Ribble Valley Borough Council  
Housing & Development Control

Application no: **3/2024/0170**

Address: **Brentwood Pendleton Road Wiswell BB7 9BZ**

Proposal: **Permission in principle application for one new dwelling.**

Client: Mr D Higgins		
Project: Proposed Dwelling Brentwood Pendleton Road Wiswell		
Dwg title: Proposed Site Plan		
Scale @ A1: 1:500	Date: 16.10.23	Drawn by: PD
Drawing no. 1473 - 102	Rev. -

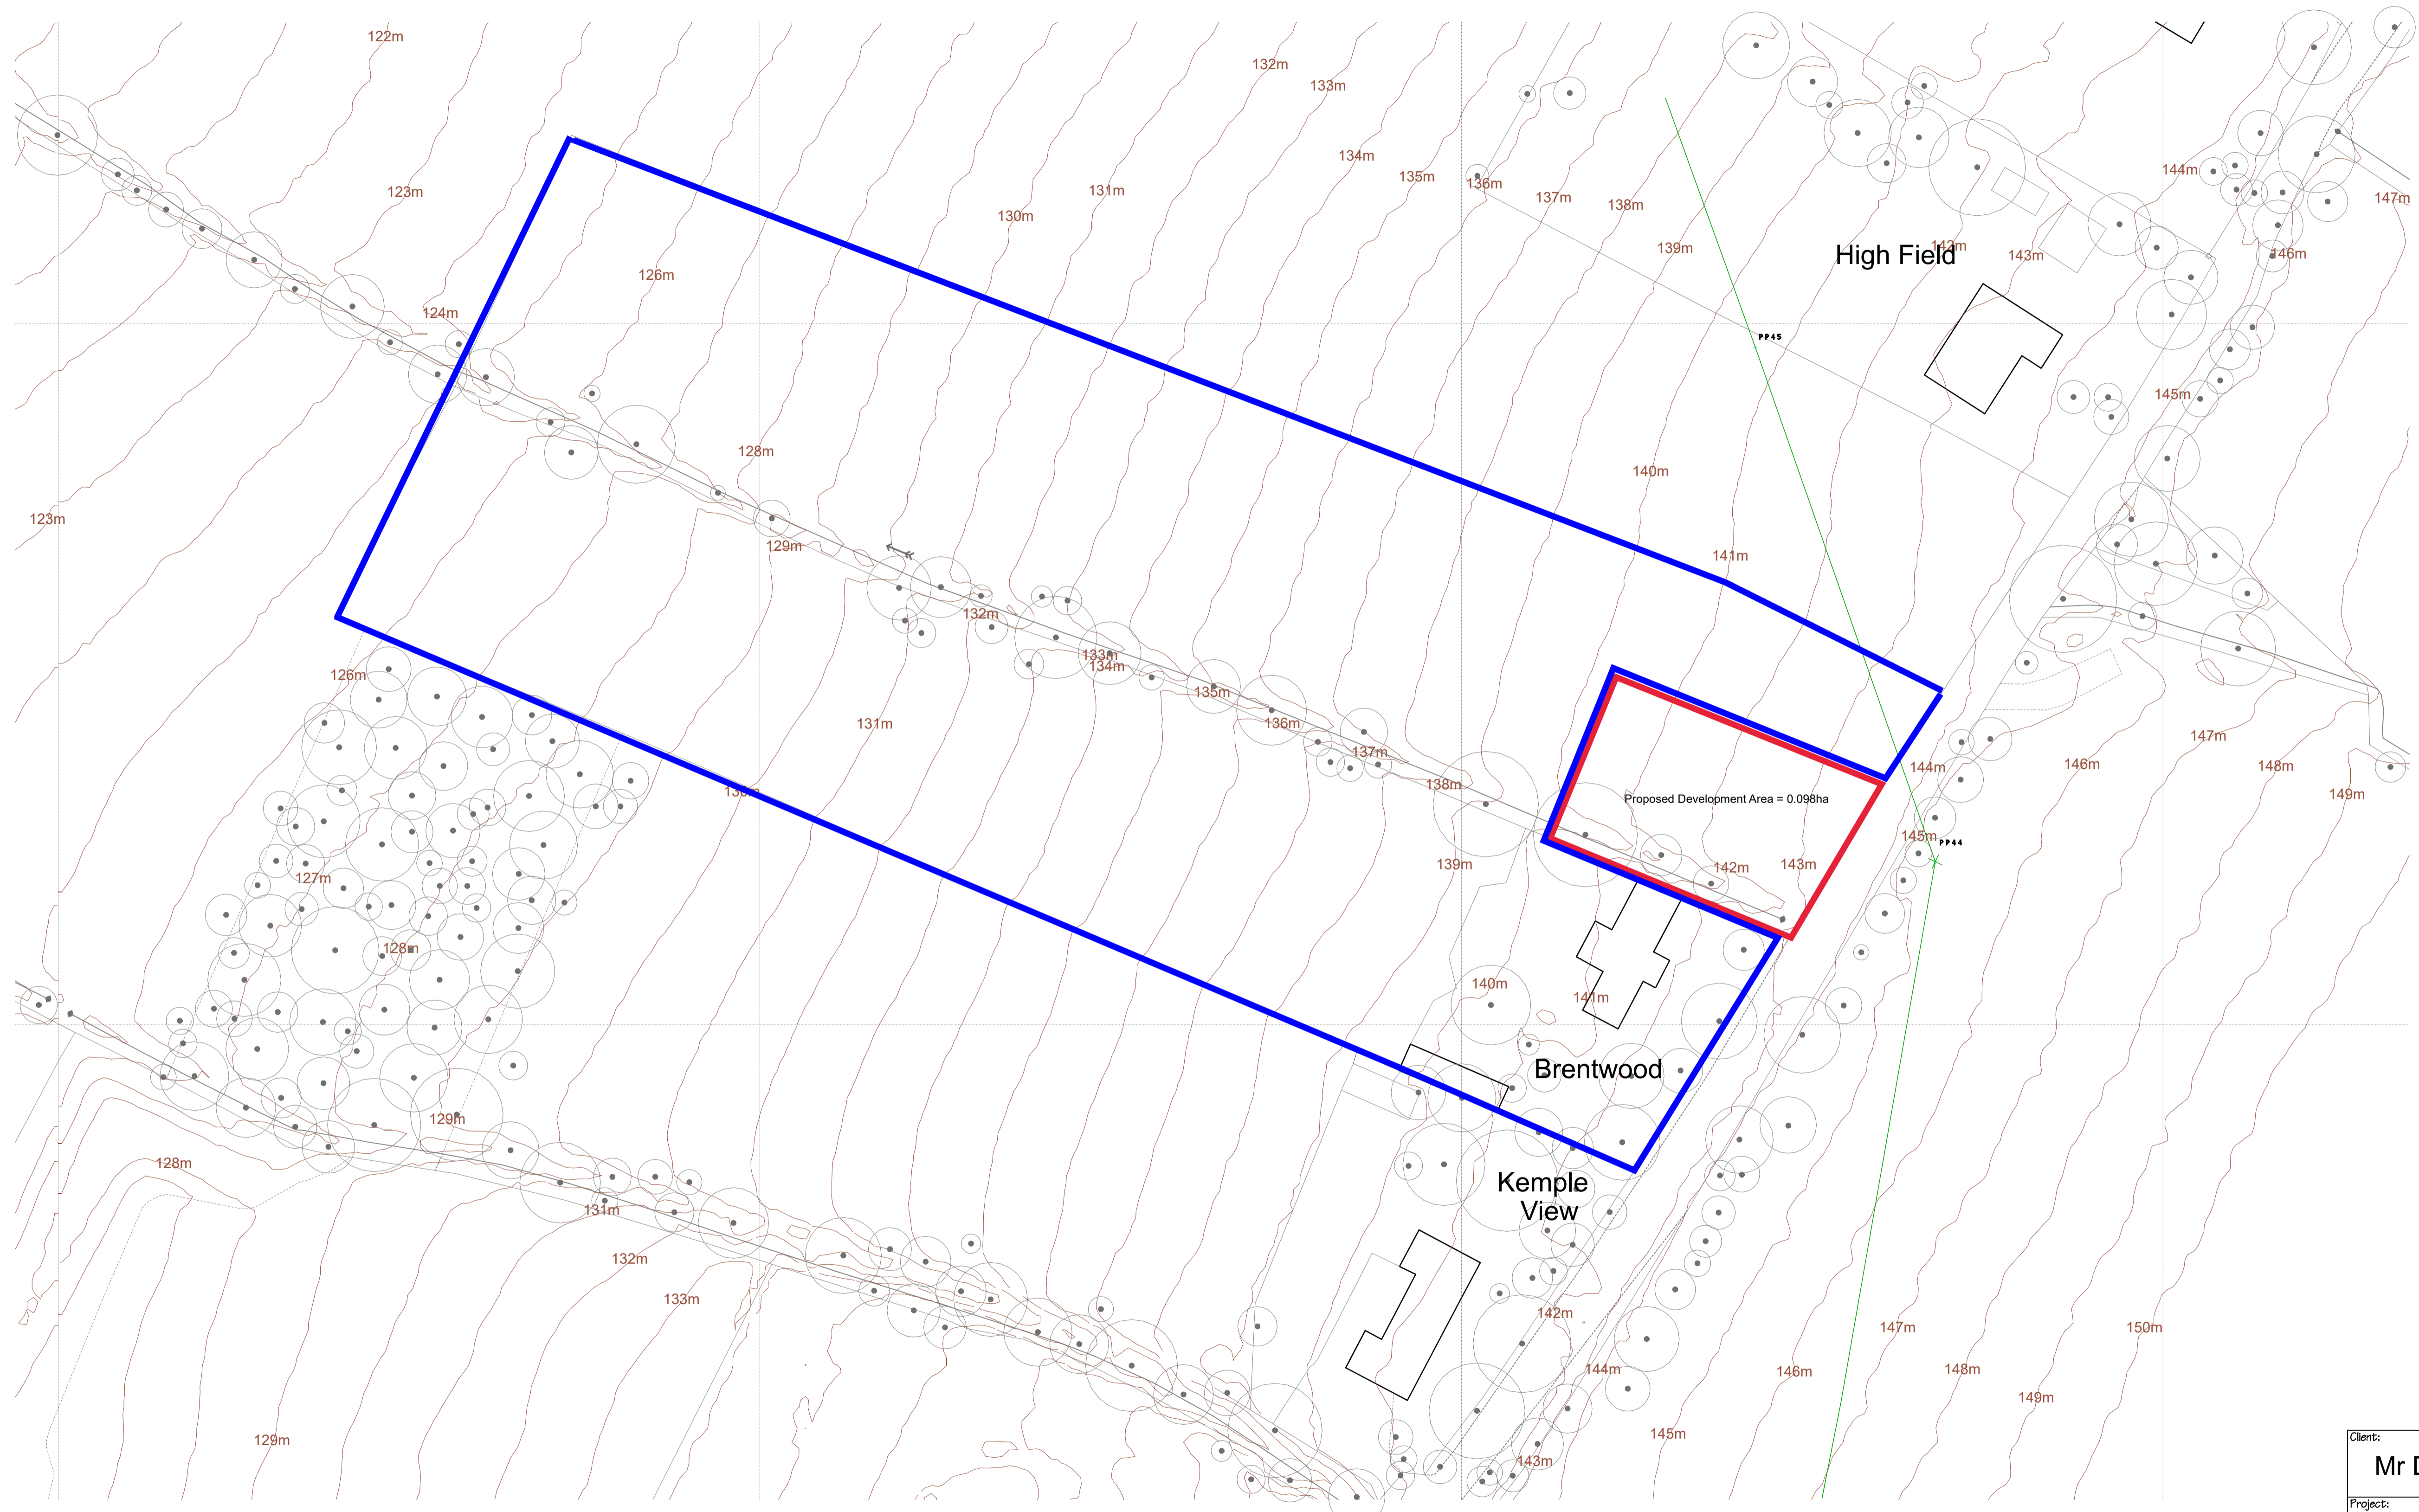
In the supporting statement, the Agent has indicated that a new access will be created off Pendleton Road to serve the site. The LHA have no objection to this with the road being straight and so vehicular visibility of 2m x 43m should be achievable. This is the same as the visibility splays for 3/2023/0566 which were accepted for the creation of a new access for the dwelling Brentwood. This was supported by a traffic survey conducted on 26th February- 4th March 2023.

The LHA will request as part of Stage 2 of the Permission in Principle that the site access is located to the north of the site. This is so that the new site access isn't too close to the access serving the adjacent dwelling.
